About the application

Application number: 2020/93467	
What is the application for?:	Erection of gates and gate posts
Address of the site or building:	Brigsteer, 402, Birkby Road, Birkby, Huddersfield, HD2 2DN
Postcode:

CLIENT:	
ACUMEN	
JOB TITLE:	
GATEPOSTS AT 402 BIRKBY ROAD, HUDDERSFIELD	
DRAWING TITLE:	
PROPOSED SITE PLAN & ELEVATION	
DRAWN: JF	DATE: Sep
CHECKED: JC	SCALE: 1:200 @ A1
DRAWING NUMBER:	2532 - 12

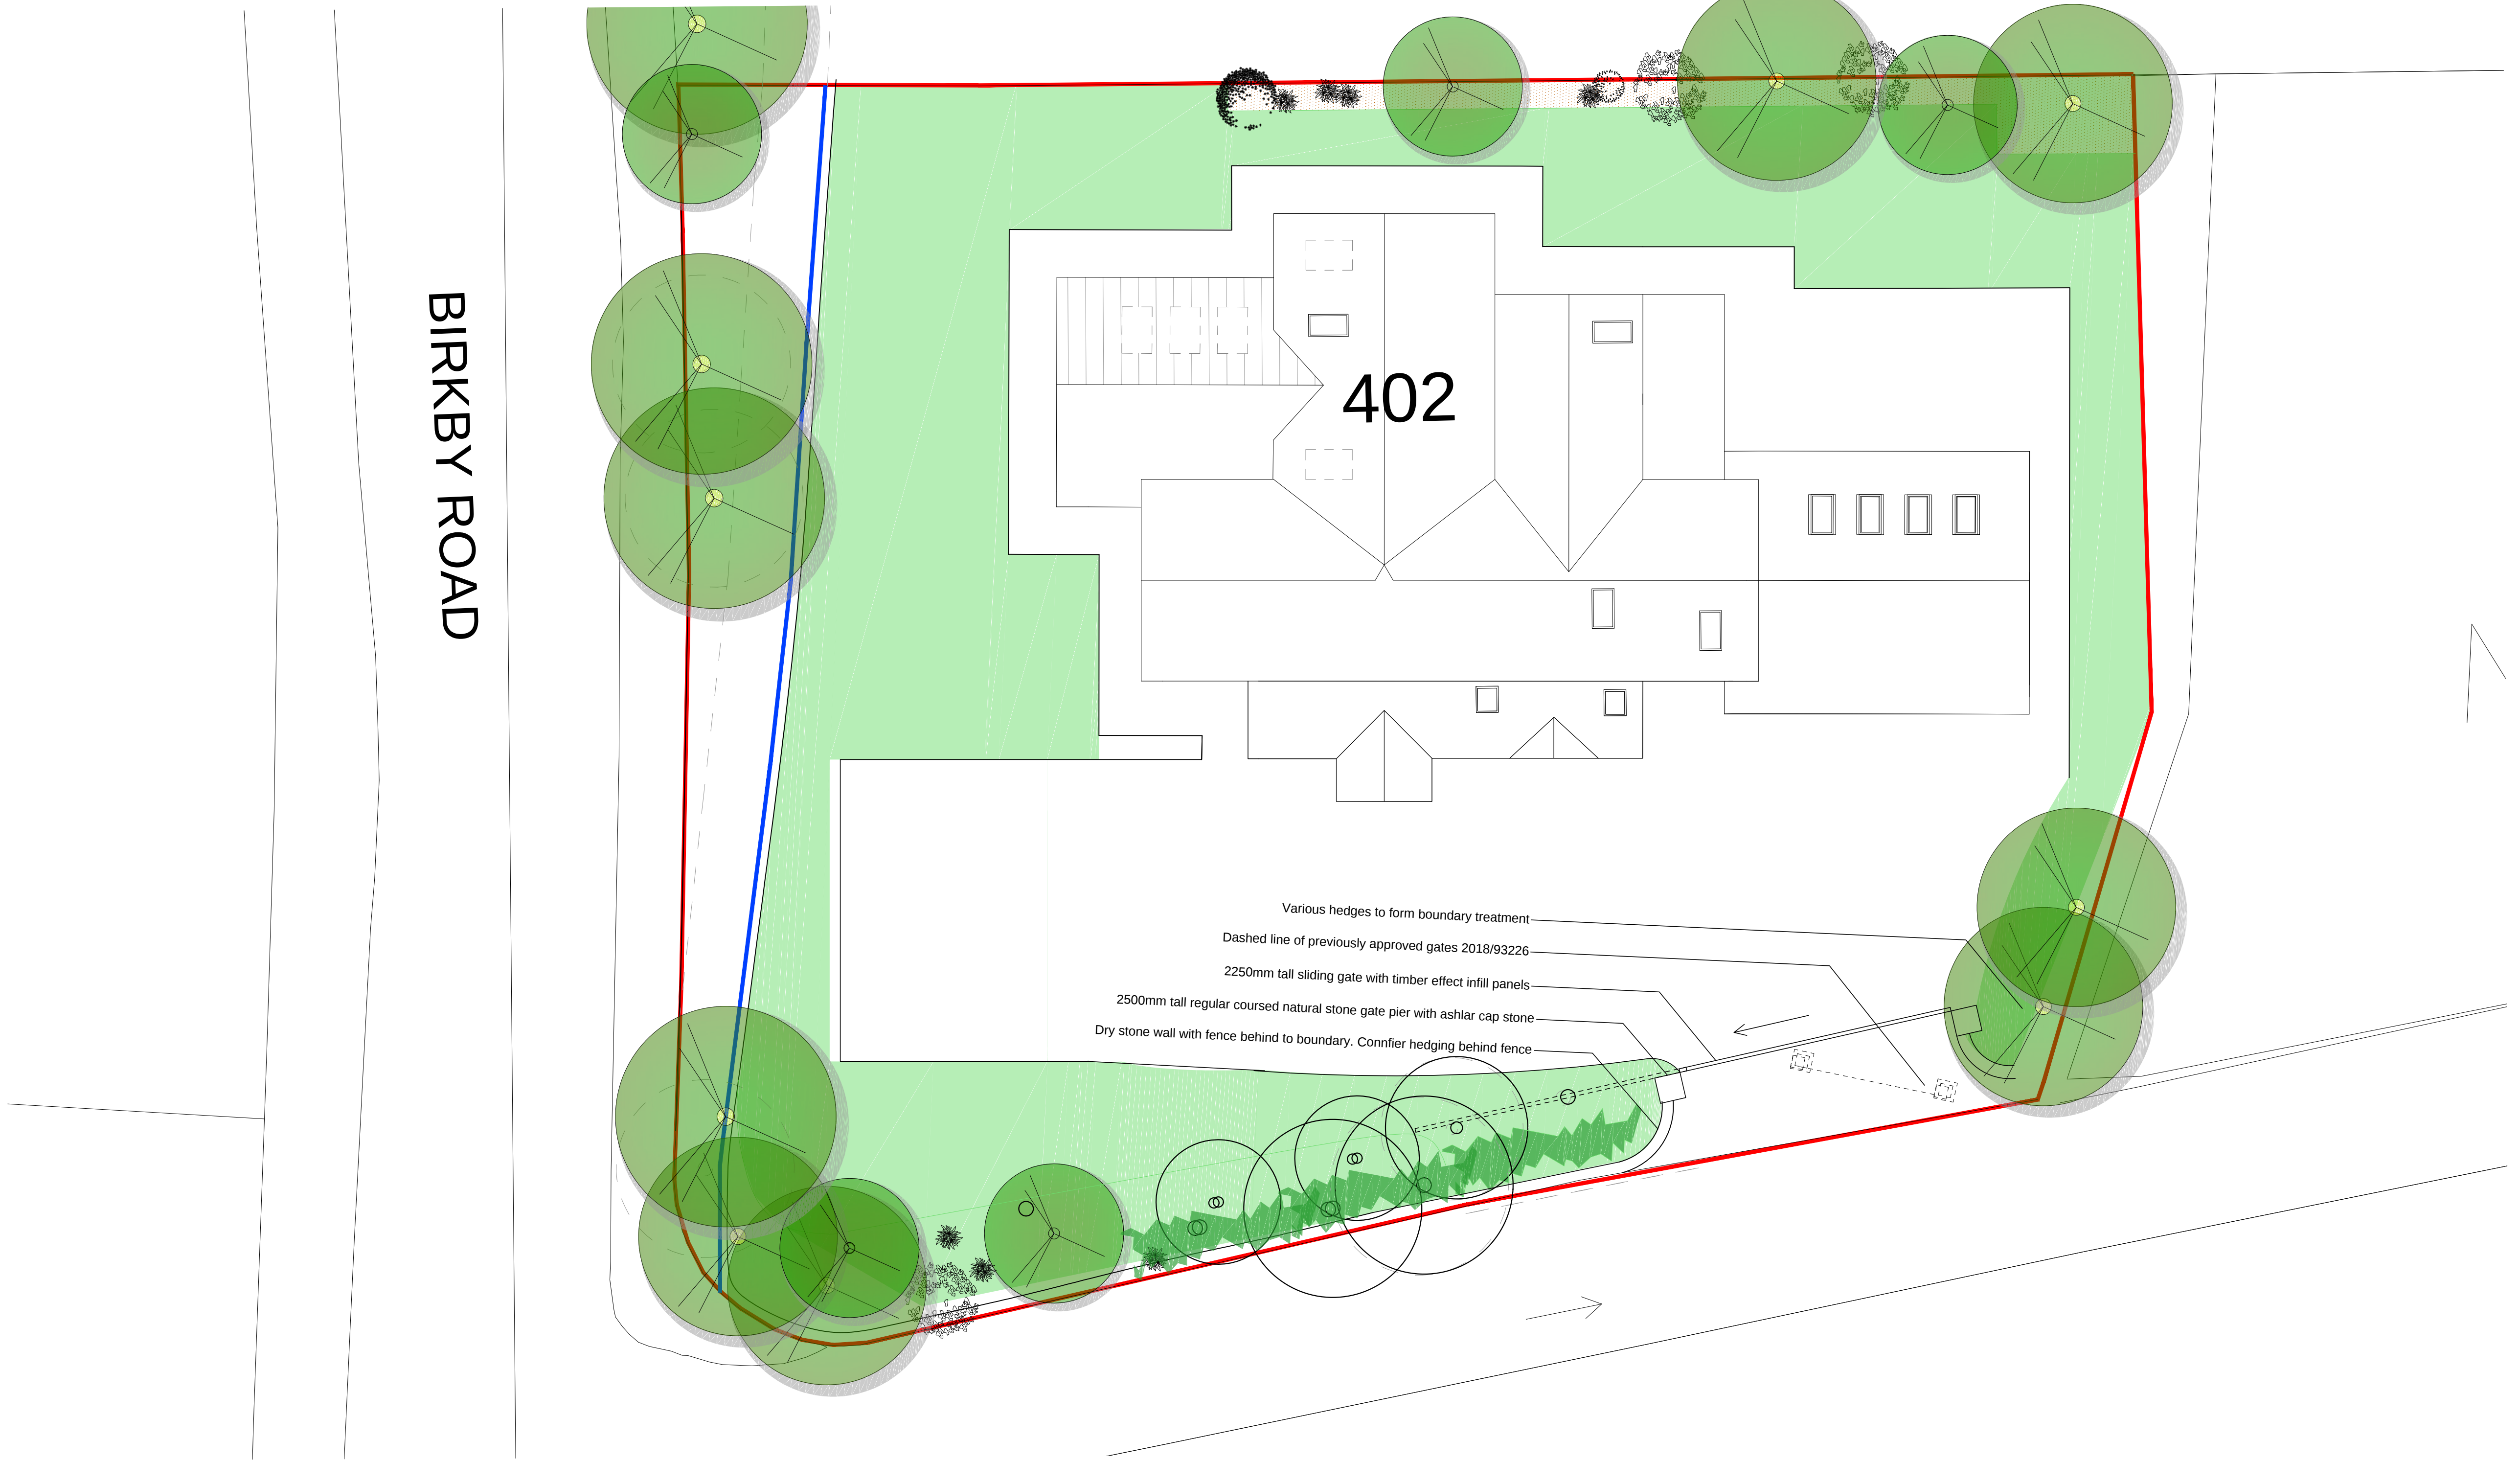
Type of comment: An objection
I would like to object to this retrospective planning application. I am local to the Birkby area and know the lane, where 402 is situated, very well. I can honestly say I was surprised when I saw the tall gate posts being built and even more shocked when I saw the enormous bulky sliding gate. I could not understand how this had been allowed and now I see that it was erected without planning permission. This gate does not belong on a residential road and together with the very tall fence, visible from Birkby road, looks very menacing . I used to admire the lane with its leafy aspect and low stone walls, and think how inviting the lane looked for a cul de sac so close to the main road. I am saddened to see an overbearing boundary fence and a huge gate reminiscent of an industrial estate. The properties in and around Birkby, do not have solid tall fences and wide solid gates; it is a much more open community and residential area, which sits well with the conservation area on the opposite side of Birkby road. I believe this application should be rejected and the gate and fence replaced with a more attractive and modest entrance sympathetic to the surrounding environment.
